CITY OF ALBUQUERQUE

Re: SAMS Academy
Traffic Impact Study/ Neighborhood Impact Analysis
Engineer's Stamp dated 07/22/2021 (A10D010)
Received 7/22/2021
CABQ Planning Transportation comments

The subject Traffic Impact Study for the SAMS Academy at 6441 Ventana Rd. NW development has been reviewed by the City's Planning Transportation Development Section. The follow corrections should be addressed in the next report submittal.

Figure 2: Study Area Traffic Network

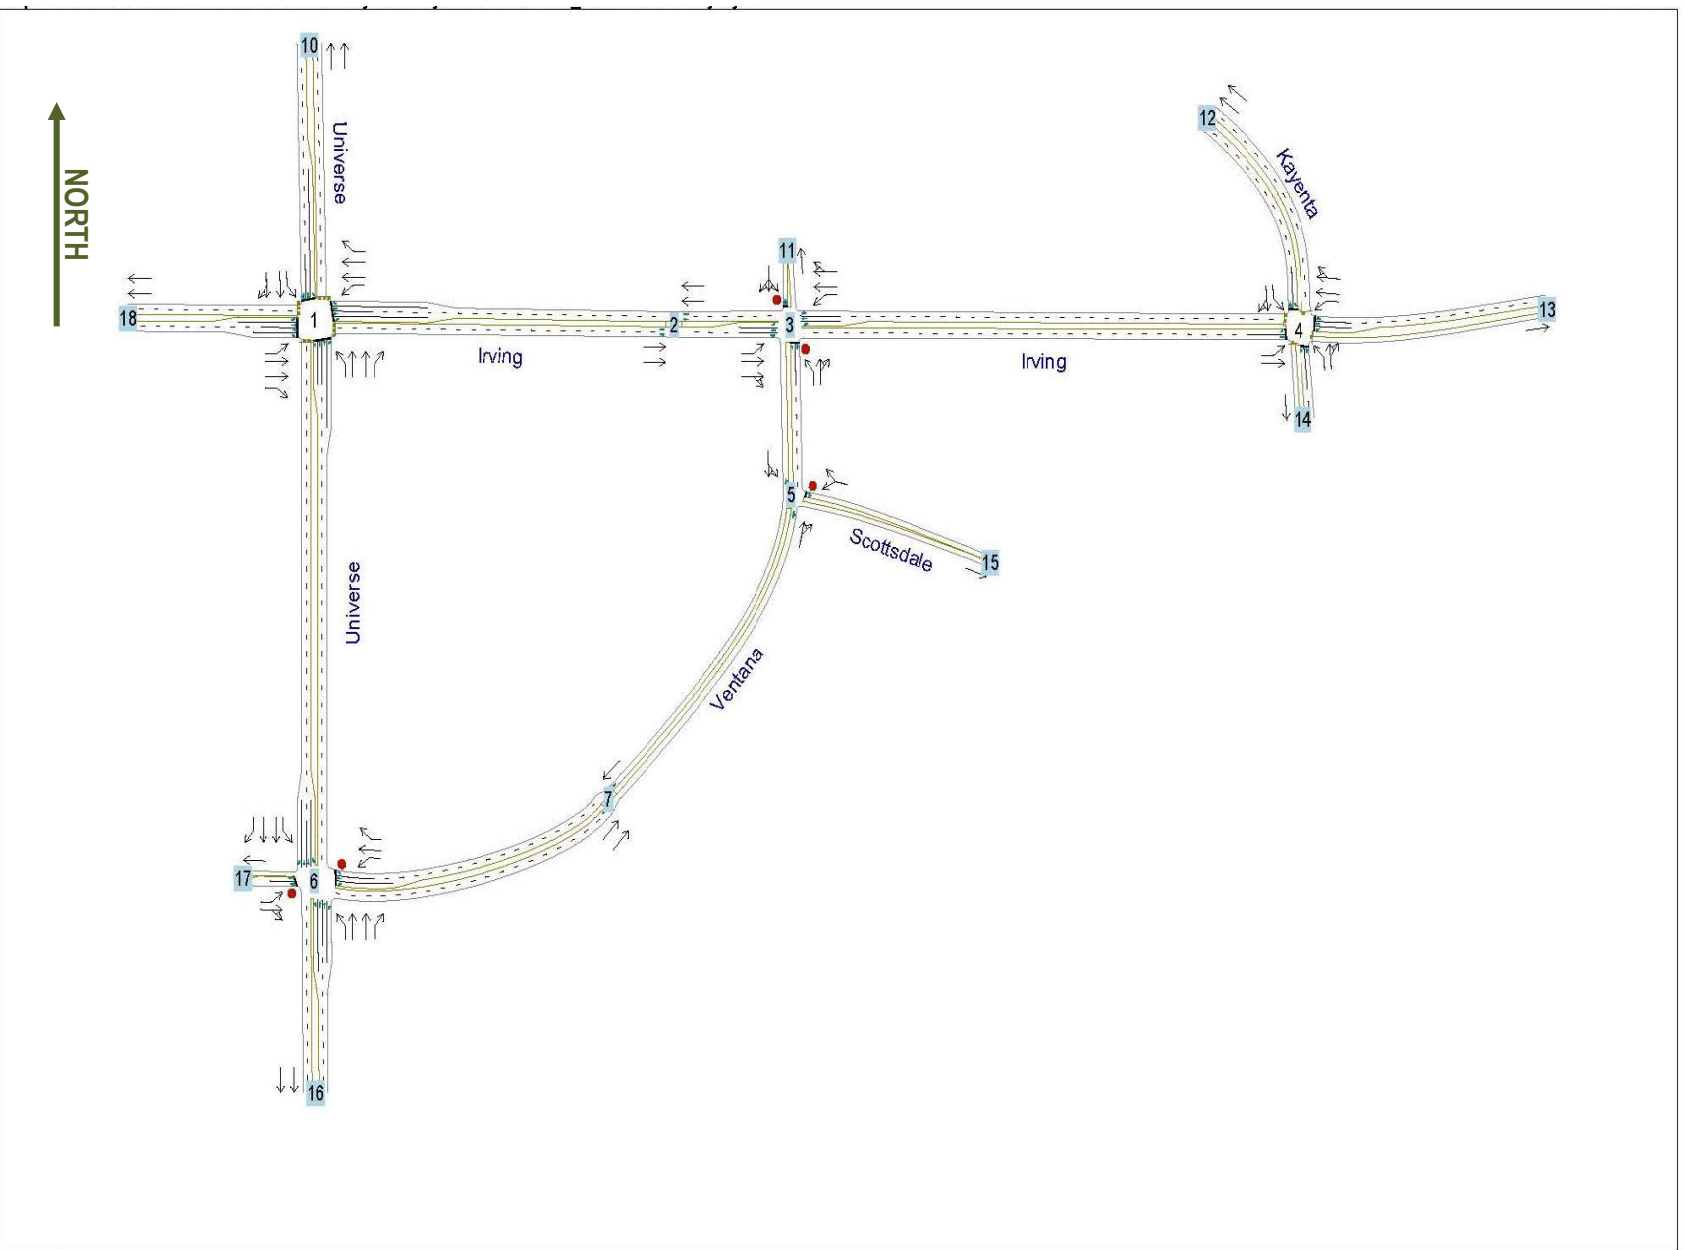
- 3.2.1 Irving Blvd is a Major Urban Collector not principal arterial
- 3.2.2 Universe Blvd. Typo 35' should be 35 mph.
- 3.2.3 Ventana Rd. describe as a local urban street.

Figure 6: Proposed Site Plan

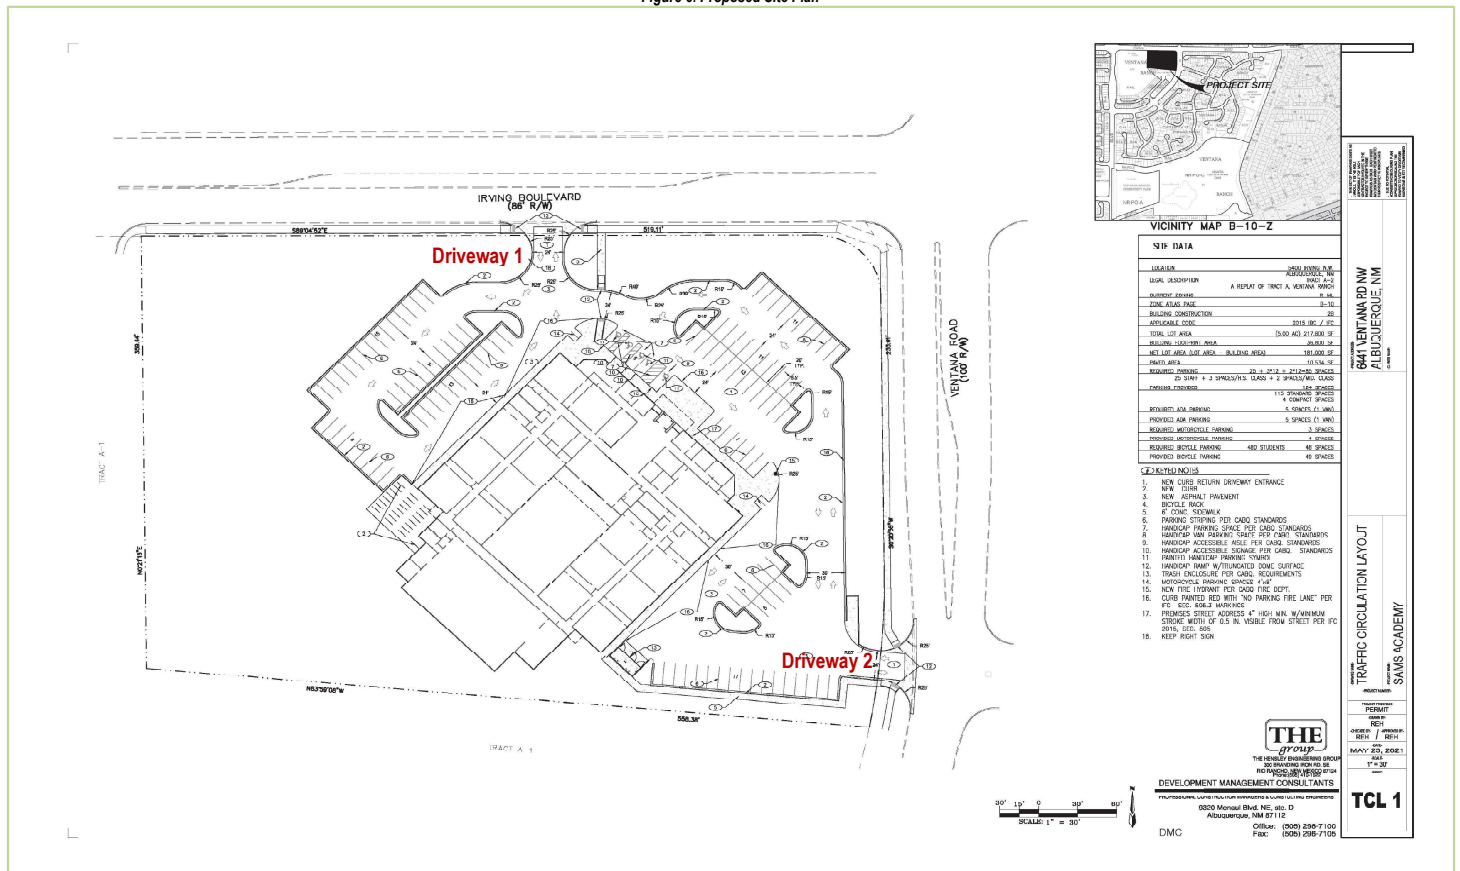
- 3.2.3 Kayenta Pl. renumber as 3.2.4 describe as a local urban street.
- 4.2.1 driveway 1 describe as a partial access
- 4.2.2 driveway 2 change full-service to full-access

- 6.4.2.3 Describe the width of sidewalk and landscape buffer as per COA DPM requirement of a local street
- 7.1.1 describe as partial-access. Driveway #1 shall have a Valley Gutter as per COA Std. Dwg. 2420

- 7.1.2 describe as full-access. driveway #2 shall be as per Private Entrance detail COA Std Dwg 2426
- 7.1.4 change Concrete aprons to Concrete Valley Gutters

- 7.1.6 sidewalk 5 feet wide with a 5 to 6 feet wide landscape buffer
- 9.1.1 Driveway #1 describe as partial access with valley gutter
- 9.1.2 driveway #2 describe as full access with valley gutter
